# CITY OF ALBUQUERQUE

**Re: McMahon Shopping Center**  
**10550 Unser Blvd NW**  
**Traffic Circulation Layout**  
Architect's Stamp 07-20-2021 (A11-  
D017B)

Based upon the information provided in your submittal received 11-16-2021, the above referenced plan cannot be approved for Building Permit until the following comments are addressed:

PLAT OF
UNSER AND MCMAHON CENTER
WITHIN THE TOWN OF ALAMEDA GRANT
PROJECTED SECTION 2, TOWNSHIP 11 NORTH, RANGE 2 EAST, N.M.P.M.
BERNALILLO COUNTY, NEW MEXICO
SEPTEMBER 2021

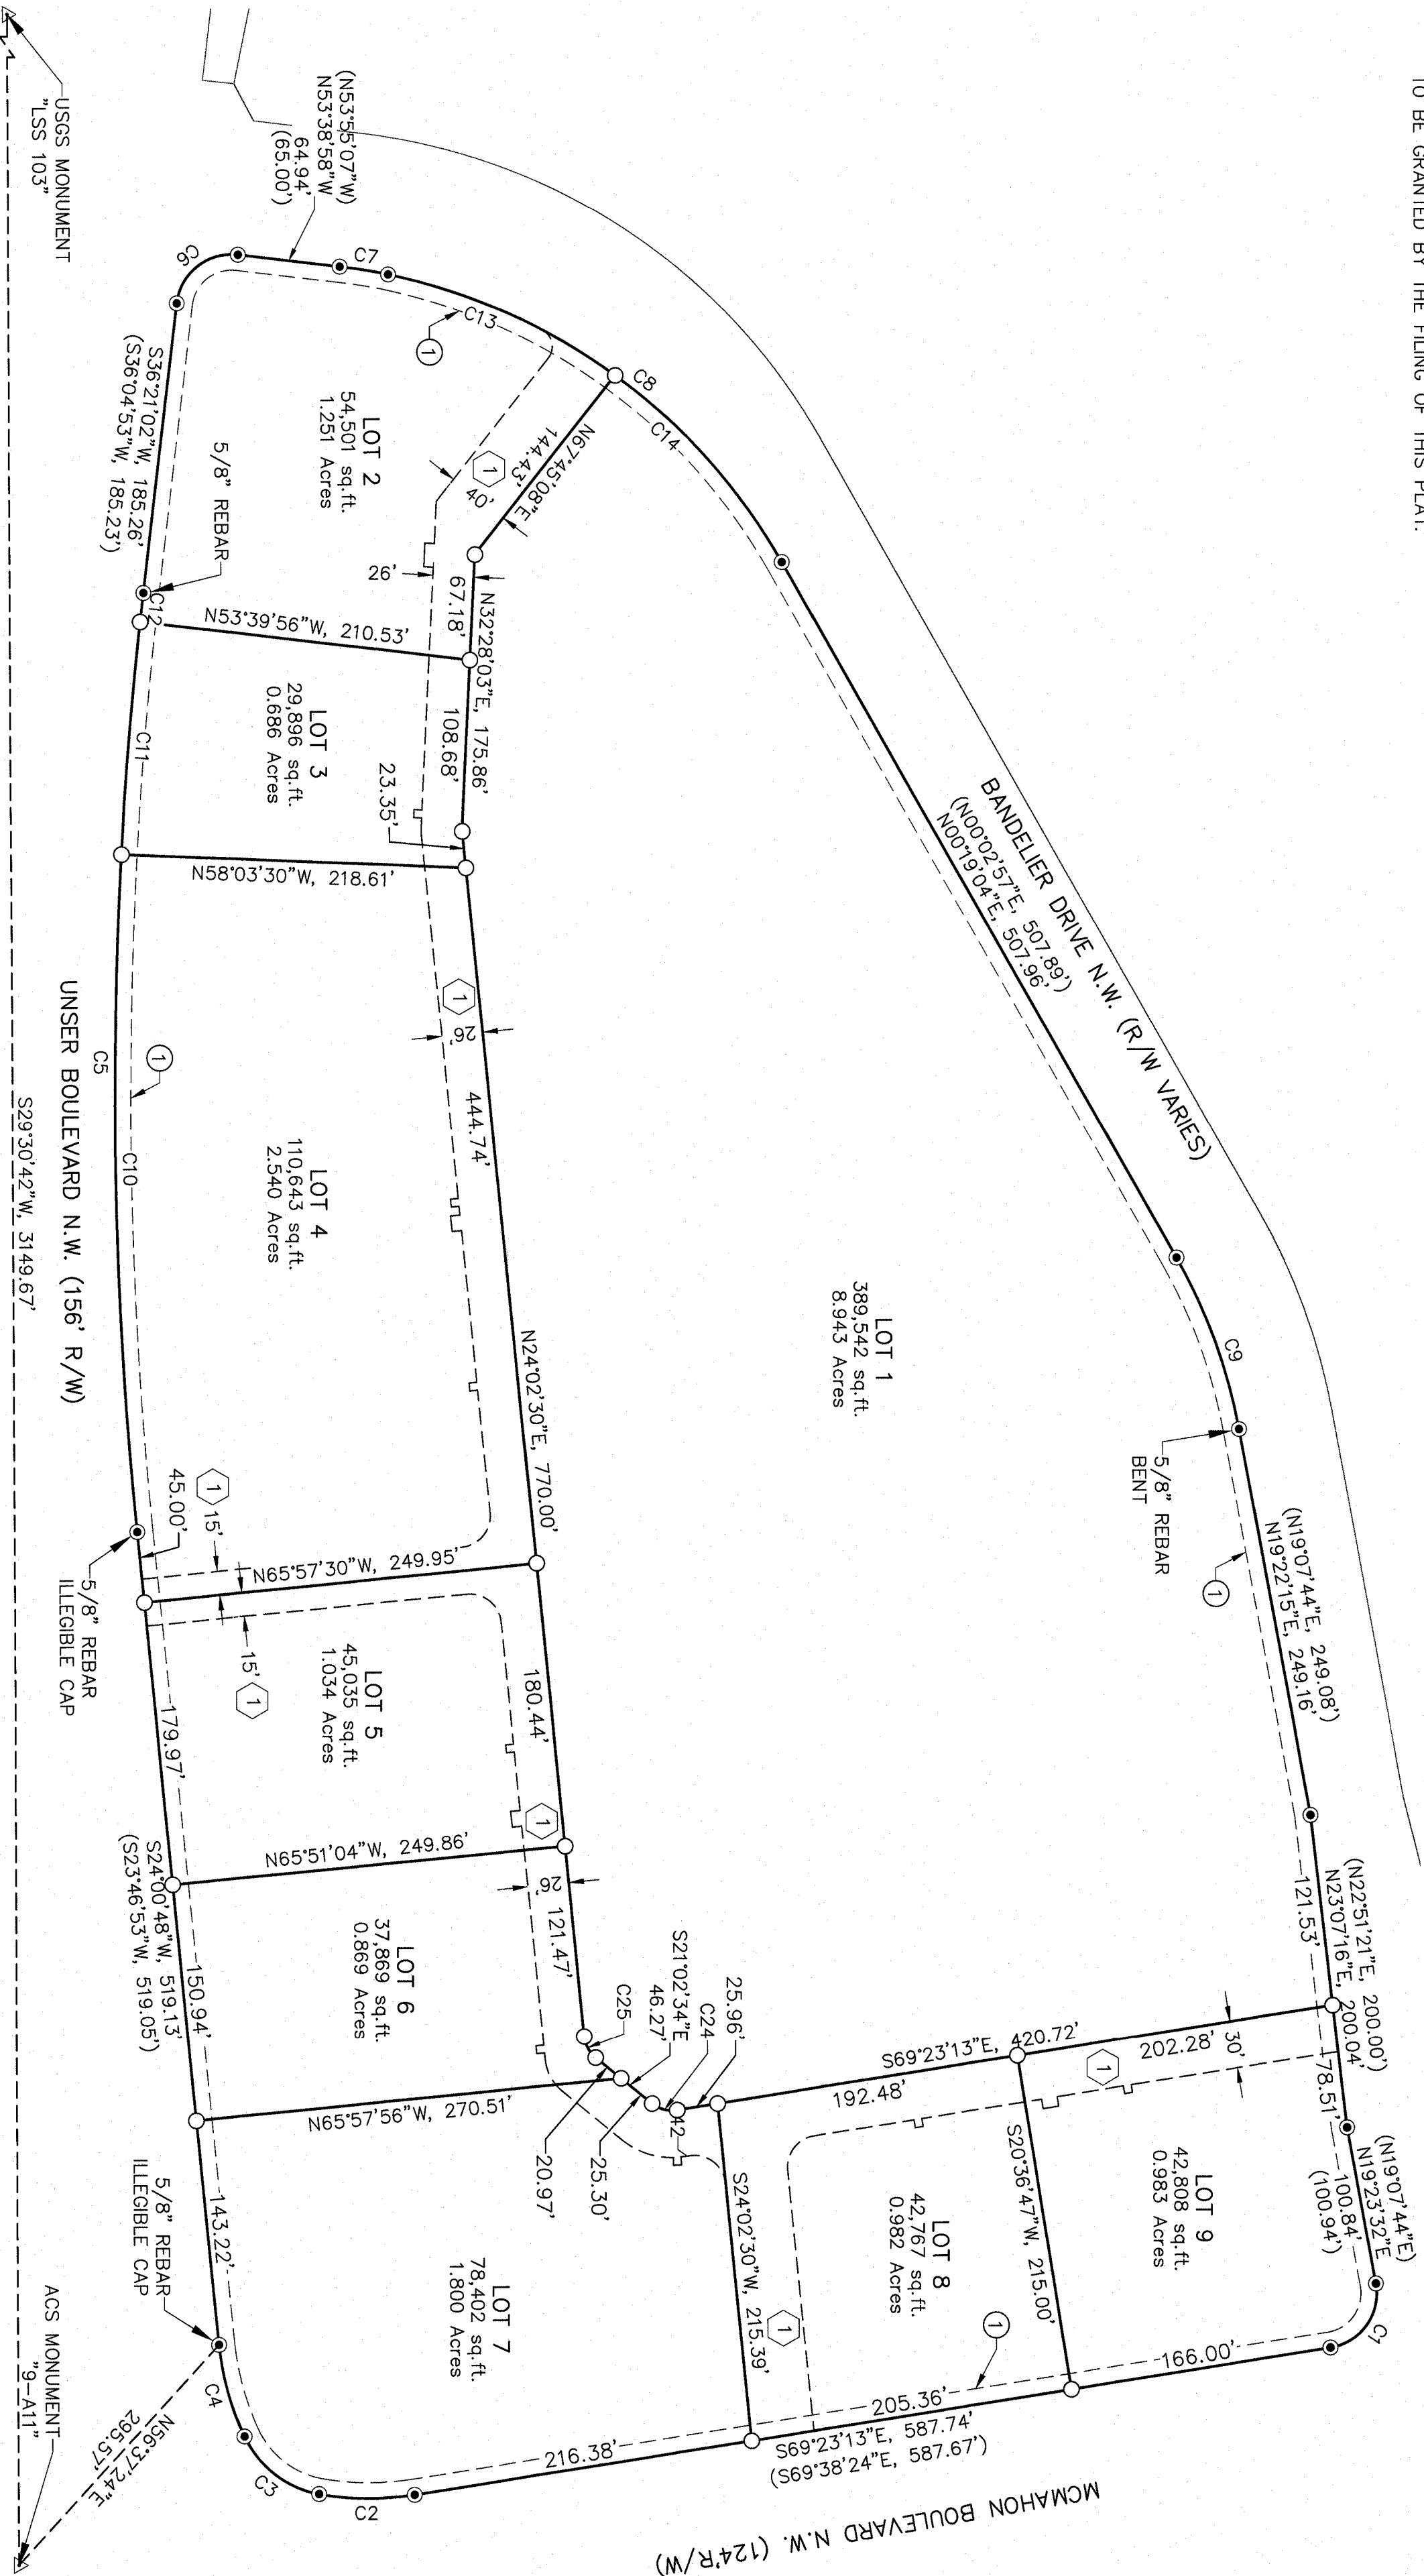
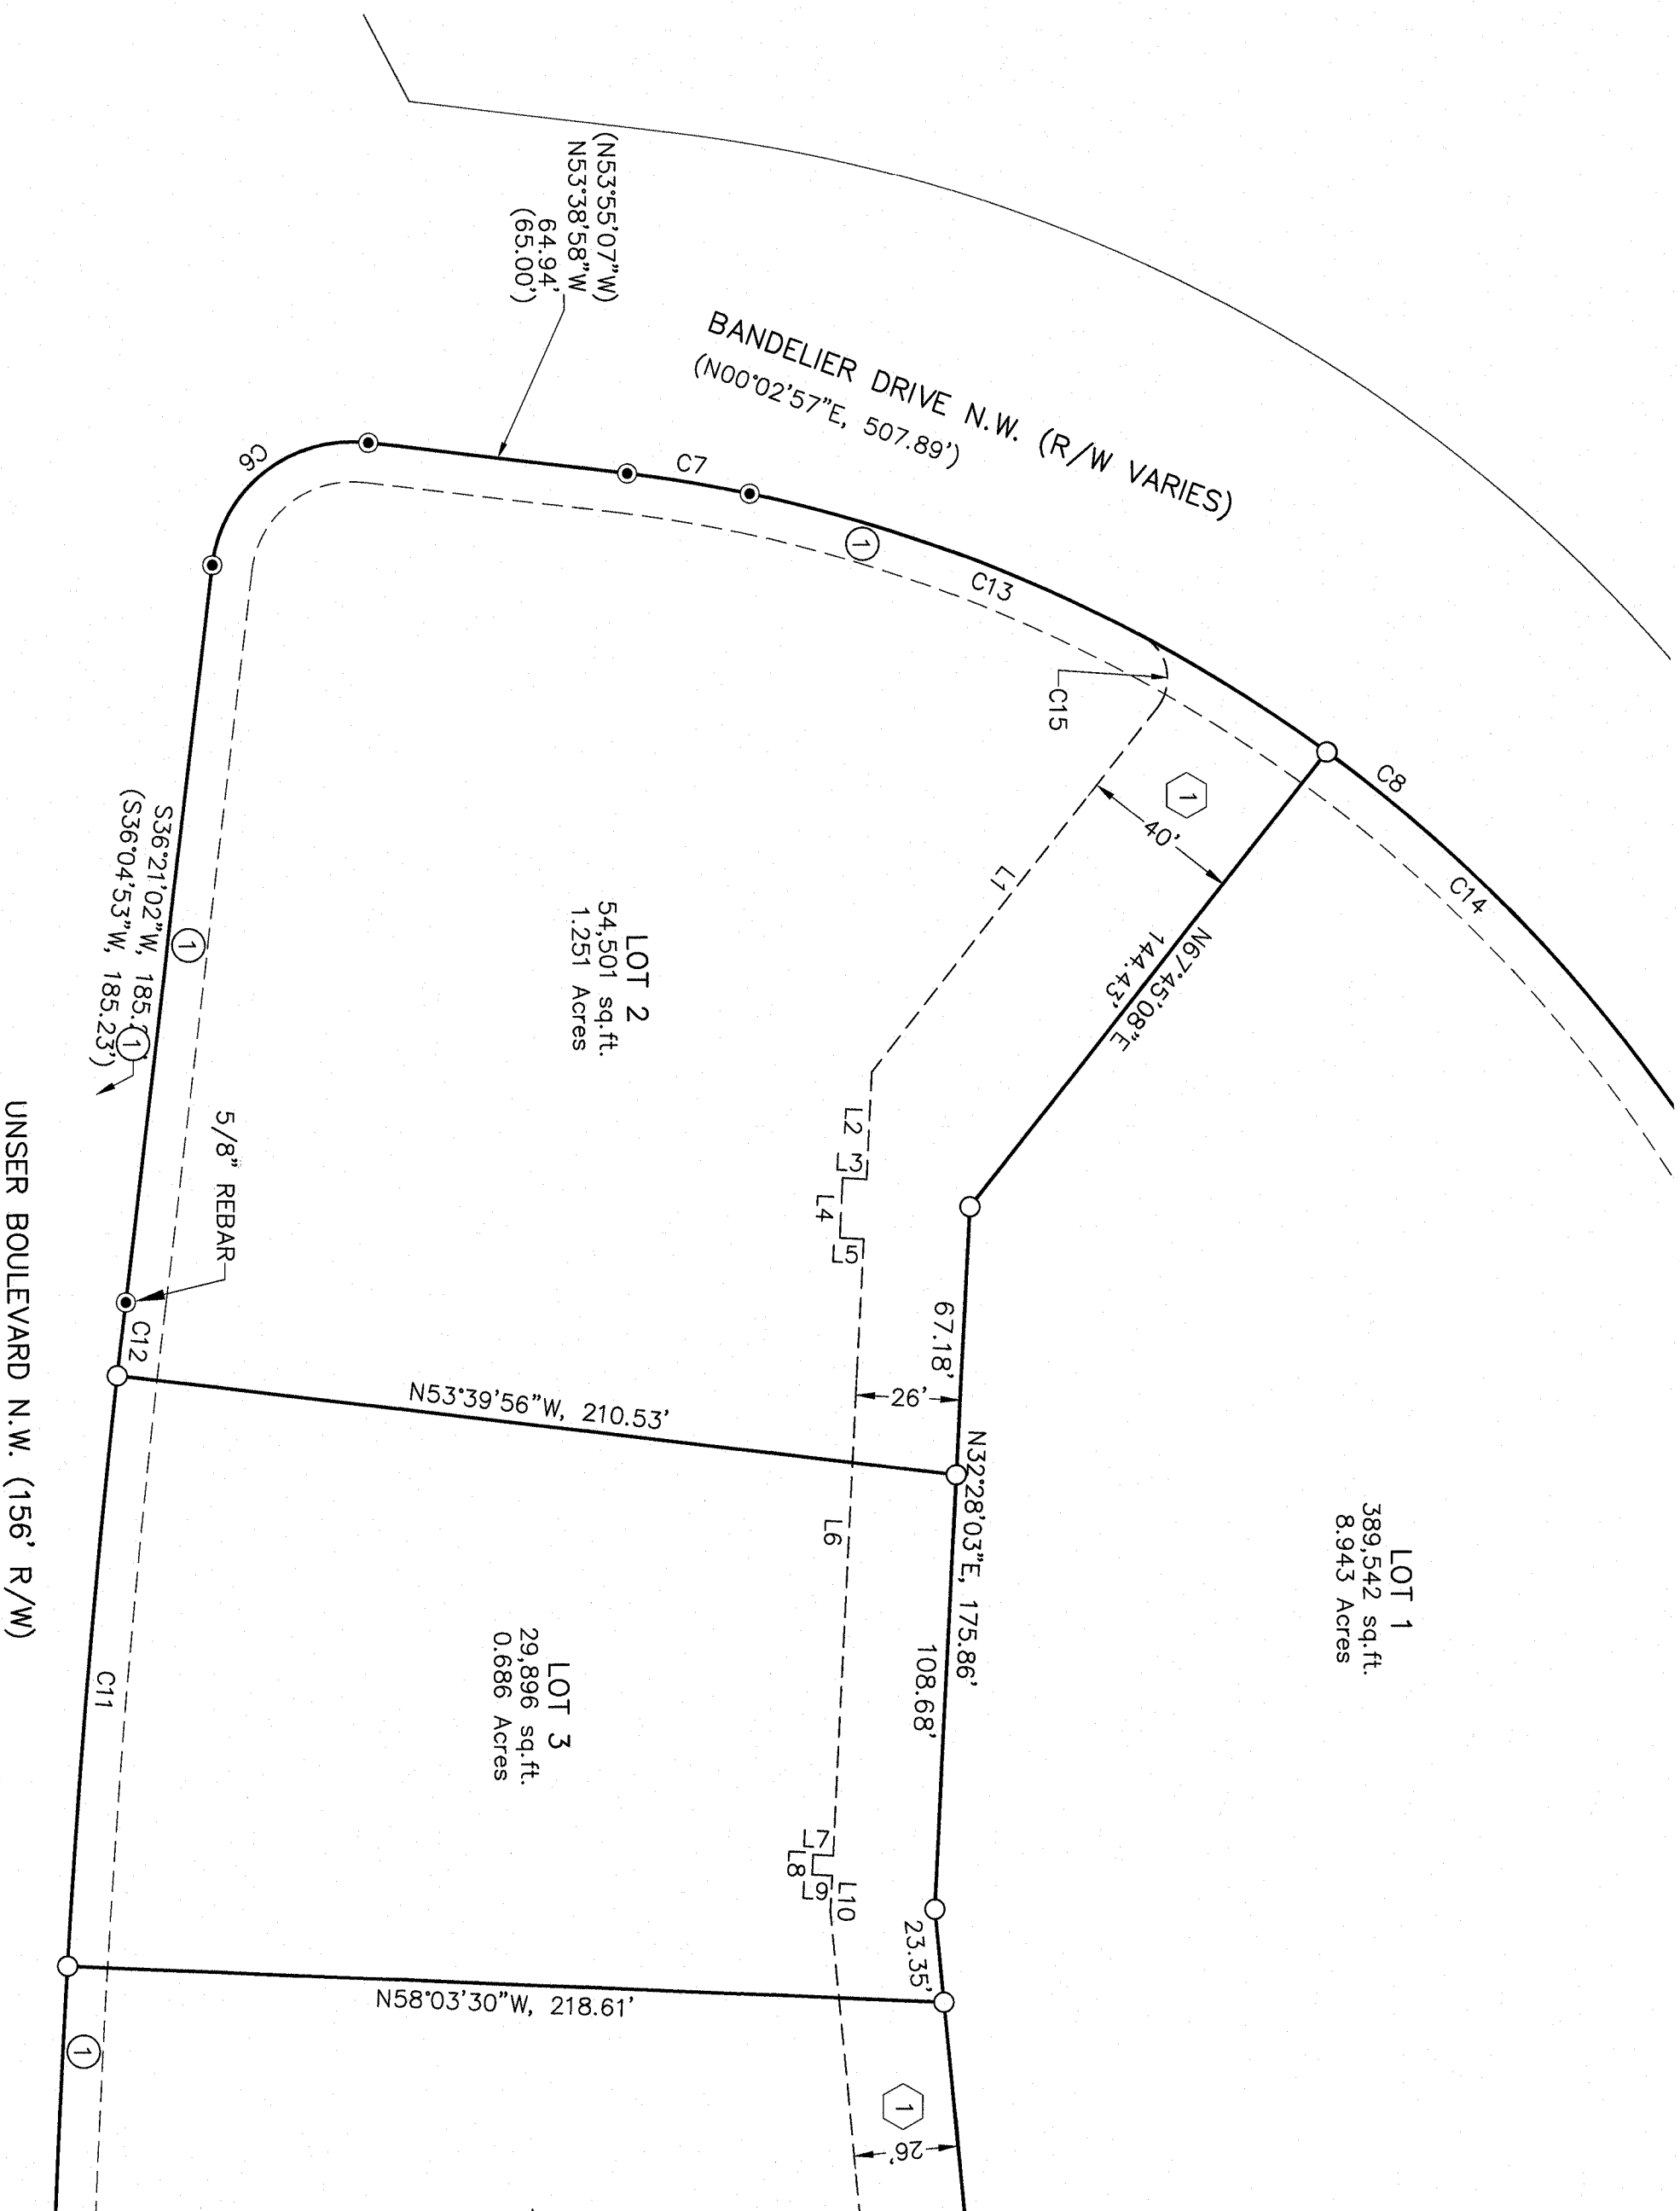
1. An approved PLAT will need to be provided to demonstrate plotted tracts/lots. **This includes all 7 sheets.** I will need these sheets to review all access/pedestrian easements being proposed on this TCL project.

- You will need adjacent land owner permission to have ramp or property. Of course, the Plat hopefully shows an easement for this encroachment and/or land owner agreement to have ramp located on their frontage.
